From: Martyn White
Sent: 05 July 2019 09:18
To: Planning.Responses <Planning.Responses@arun.gov.uk>
Subject: A/61/19/HH

A/61/19/HH

The application is for a single storey front porch extension, single and two storey rear extensions, along with a new vehicle access. The building forms part of a small terrace of houses and is located within the Angmering Conservation area.

Front (North) Elevation

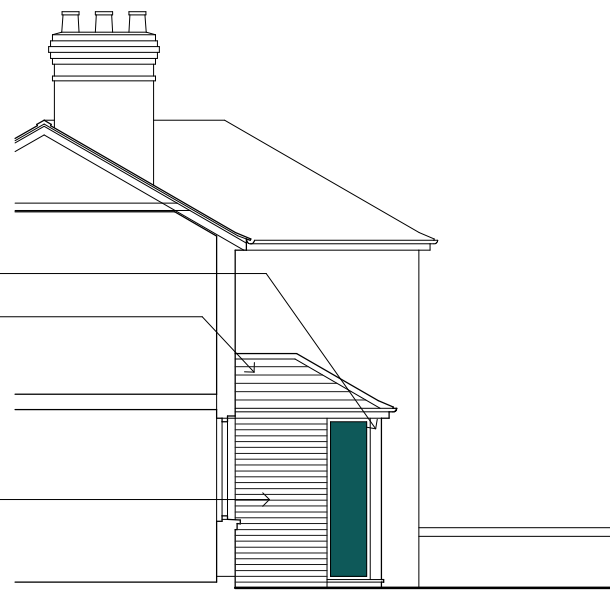
With respect to the proposed works, it is considered that as the porch will look similar to those on the remainder of the terrace, and as a consequence, it will have a neutral impact.

Front (North) Boundary Wall Elevation

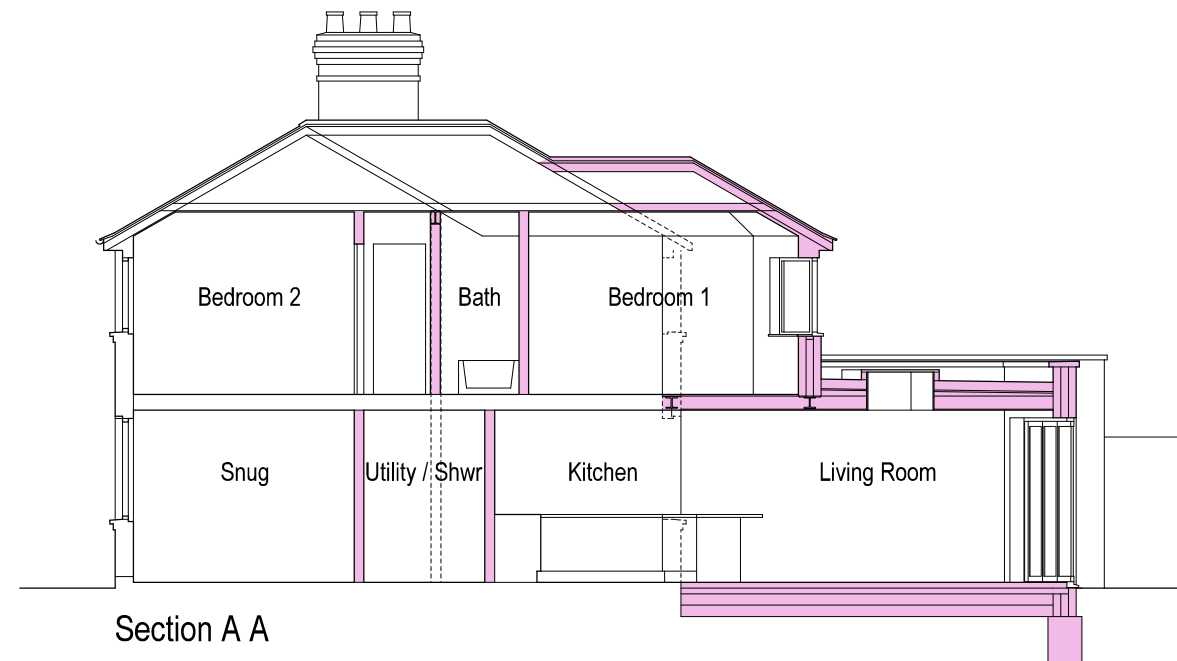
The loss of the walling is unfortunate; however, I note that small sections of the wall will remain in situ, which will retain a memory of its presence. Any new bricks required in order to create the opening should match those in the existing wall.

Rear (South) Elevation

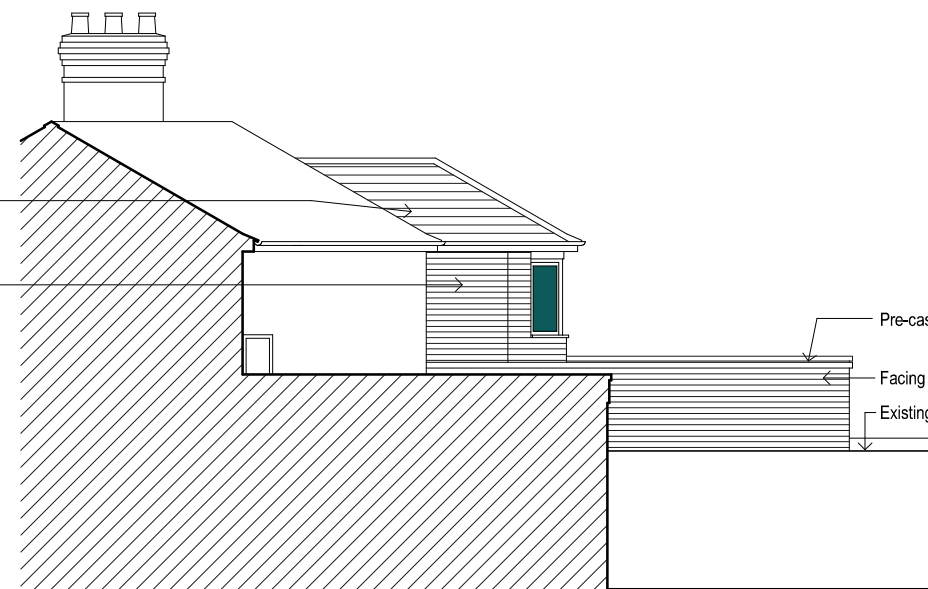
The development to the rear of the property will not be visible from the public realm, and are considered to be acceptable, in this instance.
